The Secretary,  
An Bord Pleanála,  
64 Marlborough Street,  
DUBLIN, 1.

Re: Irish Rail Draft Railway Order, July 2022 - Dart+ West Electrified Heavy Railway Order 2022

I want to make an observation concerning a section of the above proposal from Irish Rail's Plans for Ashtown level crossing.

# Ashtown

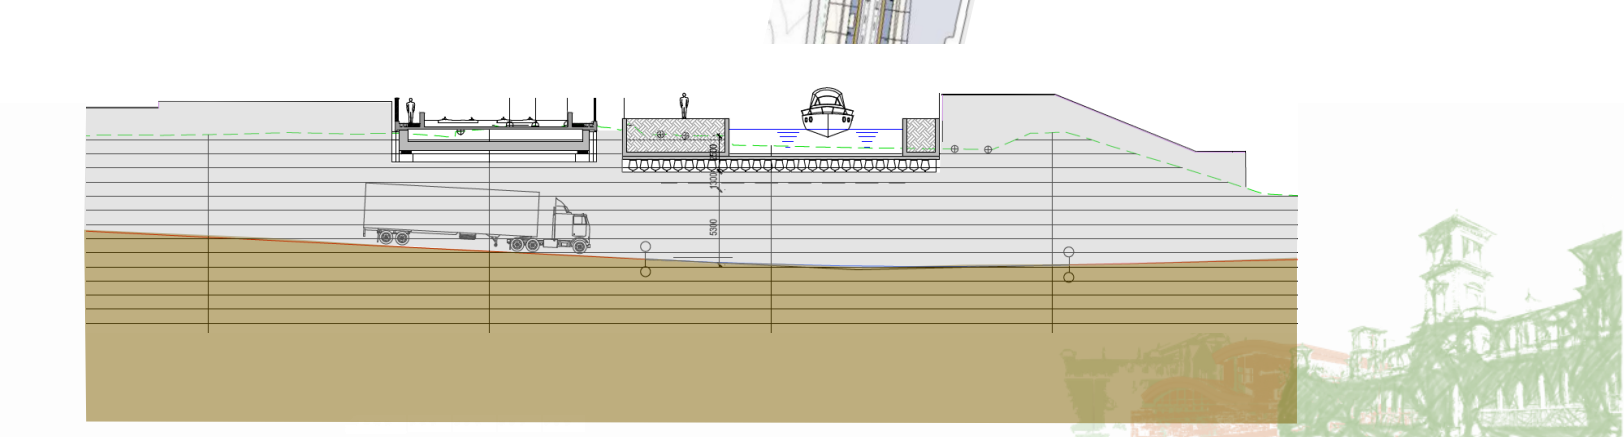
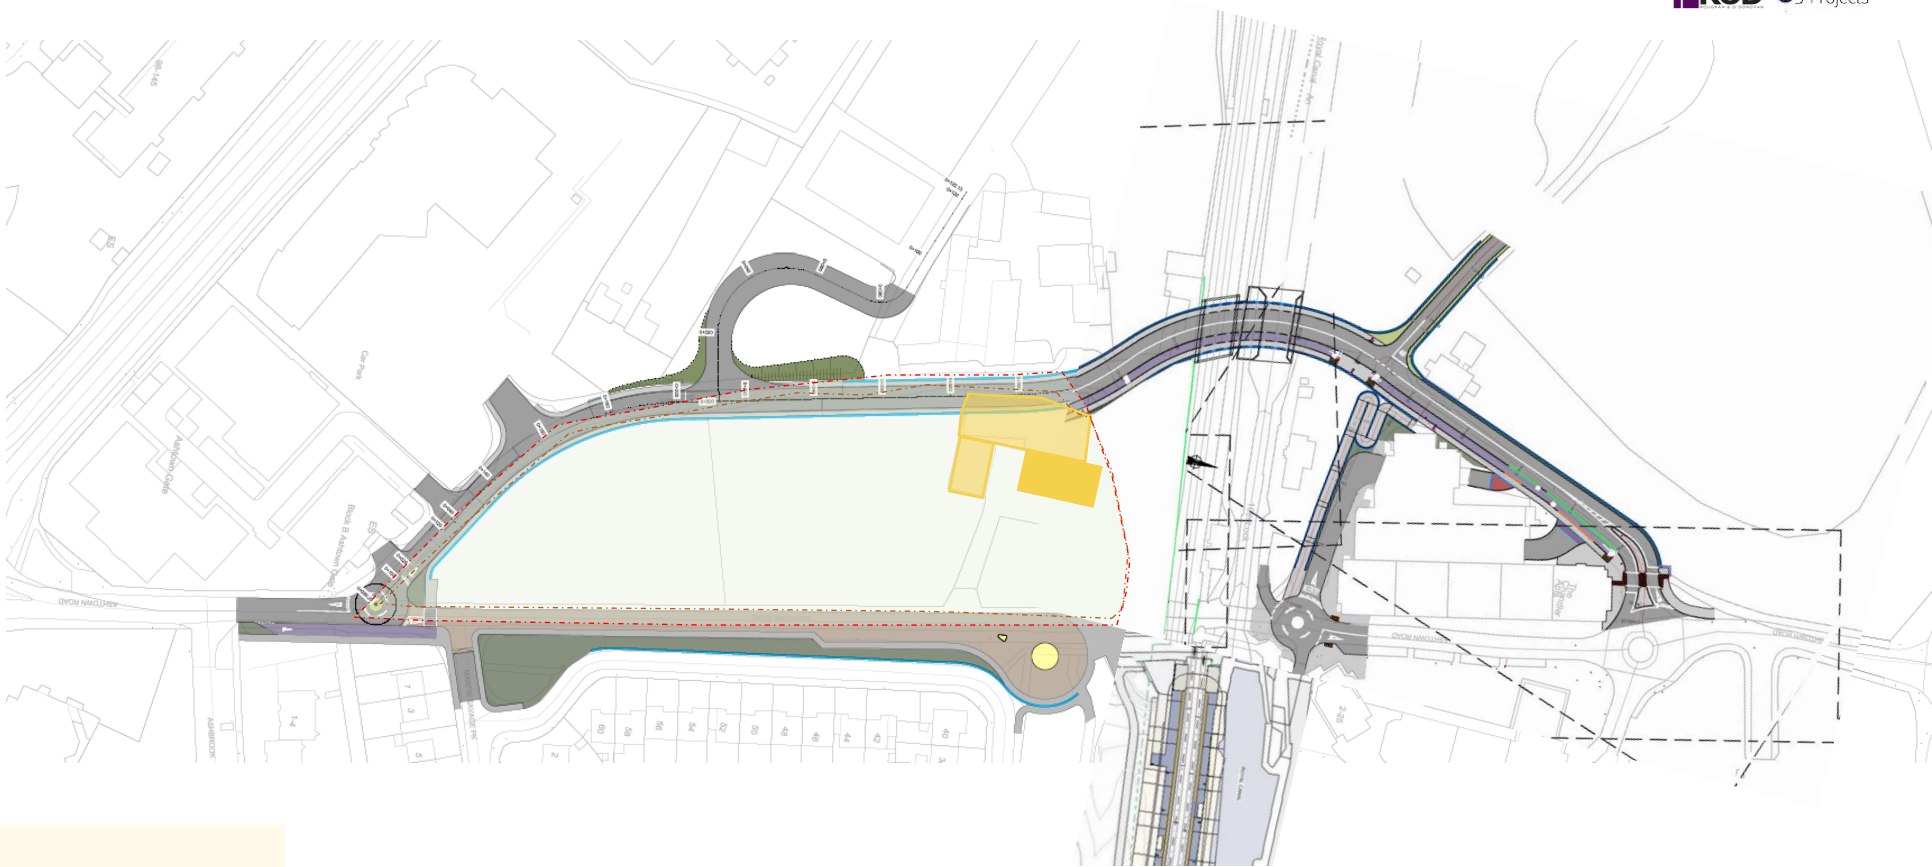
- a) The imposition of a tunnel would sever the communities on either side of the railway line. It is unrealistic to think that people will negotiate a much longer walk, descending 8 metres into a 30 metre tunnel and reascending 8 metres on the other side OR traversing a high stairs/long walkway over the railway line. This is not practical nor is it safe.
- b) The plan also threatens existing long standing local amenities, particularly the riding stables, an industrial estate, several protected structures and a wetland to the west of the station.
- c) The proposed destruction of green space in Martin Savage Park, through the installation of a sub station, which will evidently extend beyond Irish Rail's existing property
- d) A convoluted set down point, detouring vehicles away from the main road and the station. In practice, nobody would be inclined to use this.

The most practical option is to lower the level of the rail line to go under Ashtown Road.

- a) Avoid division of communities on either side of the line.
- b) There would be no need for expenditure on tunnelling, new roads and walkway versus lowering the railway.
- c) The proposed sub station could be accommodated to the west of the crossing, which they have earmarked for a large steps and sloped foot crossing structure.
- d) This would allow Irish Rail to make the curve alignment correction between Ashtown and Phoenix Park Stations, which they will have to do eventually.
- e) Taking into account the long term maintenance costs of the extra roads, tunnel and footbridge, this option should be as cost effective as the preferred one(if not better).

This is described in Irish Rail's Option Selection Report, July 2021 (8.3.3.2.9 Option 9 – Lowering of the Railway Vertical Alignment, page 112). [extract enclosed]

It seems to have been dismissed out of hand by Irish Rail without any fact based justification.

Before making any decision on Irish Rail's proposals, I would ask that an independent evaluation of this option be made, taking account of the long term advantages to community, environment and cost avoidance, when compared to Irish Rail's current proposal..
